From: [REDACTED]
Sent: 15 March 2019 12:34
To: Planning.Responses
Subject: FP/37/19/DOC Bay Bridge Crescent , Felpham Bognor Regis , West Sussex P022 6FW

Our Ref: NW/ARU/19/06A

RE Bay Bridge Crescent, Felpham, Bognor Regis West Sussex.

Thank you for your correspondence of 12th March 2019 regarding 'Approval of details reserved by condition imposed under FP/128/09/ relating to conditions 3-crime prevention statement, 8-details of play area, 9-maintenance of planting within any street, parking court, public open space or planted area, 12-design of street furniture, 17-confirmation of access, 18-maintenance of open space, 20-contamination risk & 25-layout & specification of & construction programme for roads, footpaths & casual parking areas/the foul & surface water drainage & means of disposal for which you seek advice from a crime prevention viewpoint.

B	03/06/18	Amended to suit WSCC comments.	HJS
A	06.05.14	Plot numbers updated.	HJS
REV. No.	DATE	DESCRIPTION	INITIALS
Client			
BARRATT			
Project Phase 5A, B & C Bognor Regis			
Title		Section 38 Layout Sheet 1 of 2	
Scale	1:500@A1	Date	Nov'12
Checked		Drawn	HJS
Drawing No.	4348:500	Rev	B

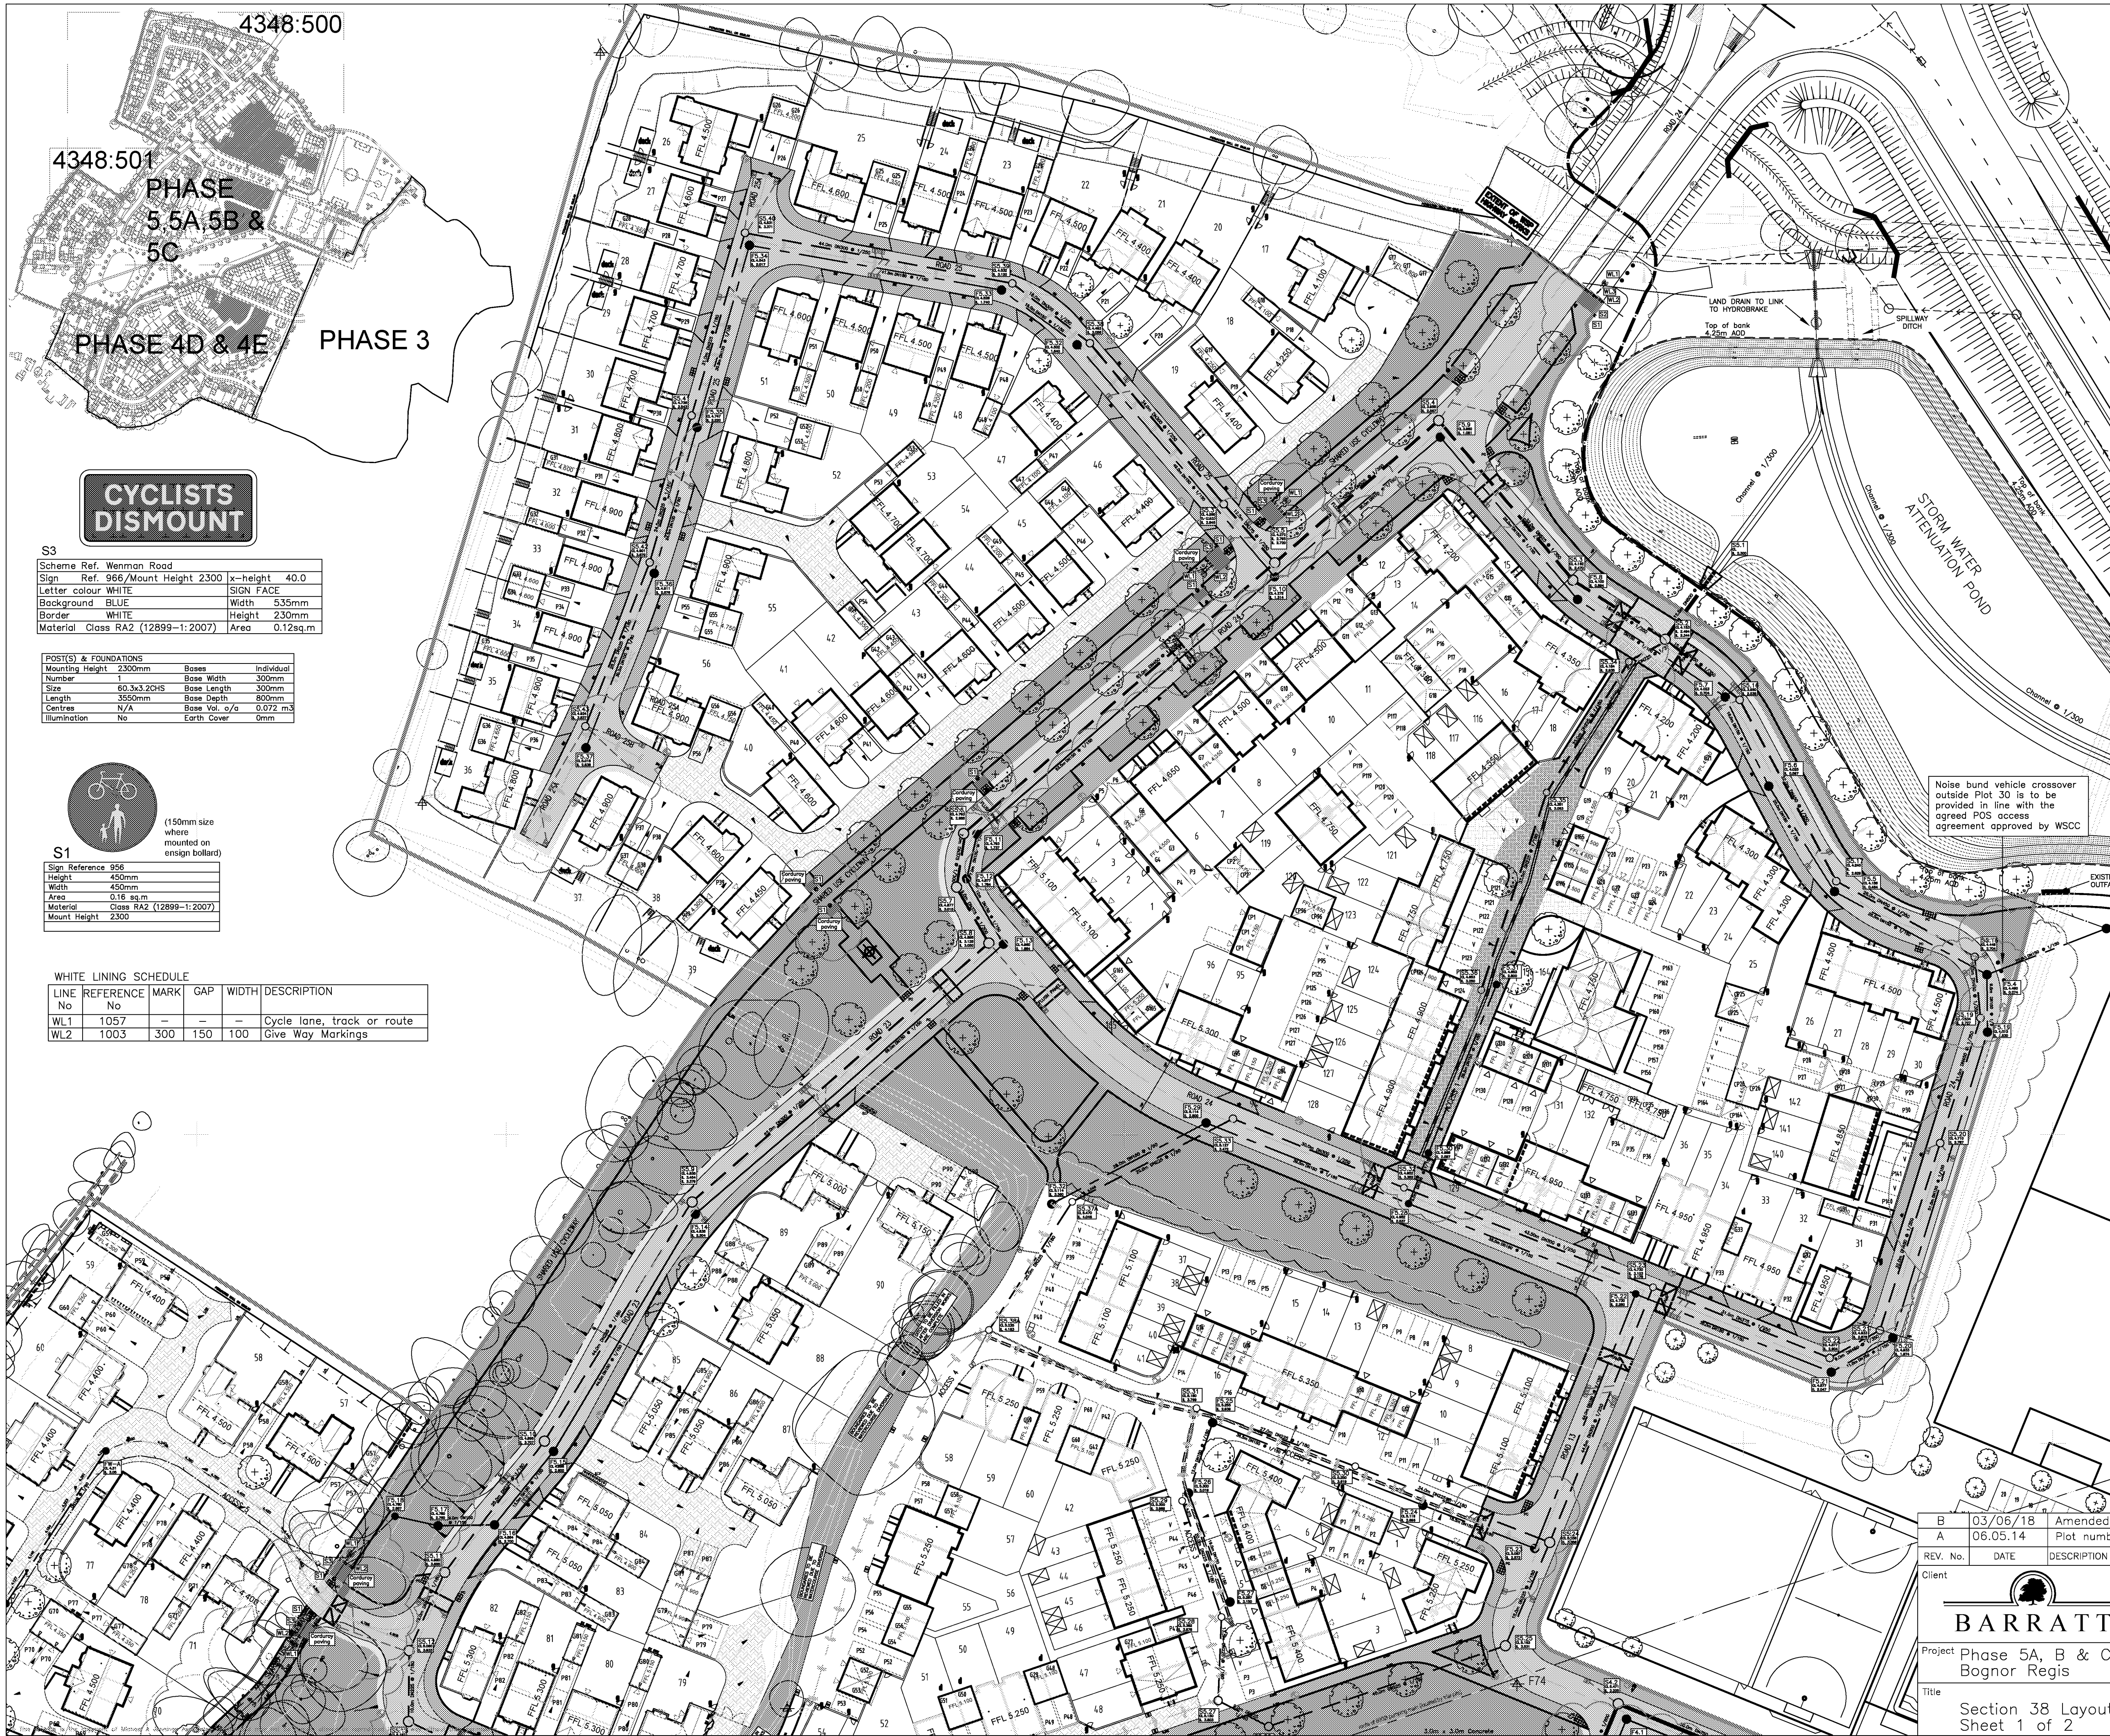
In regard to the shared footpath and cycle way, I note signage has been located for cyclists to dismount at junctions within the development but, physical barriers may also have to be put in place where 'desire' lines (unsanctioned direct routes) place users in danger, such as busy road junctions as signage may be ineffective.
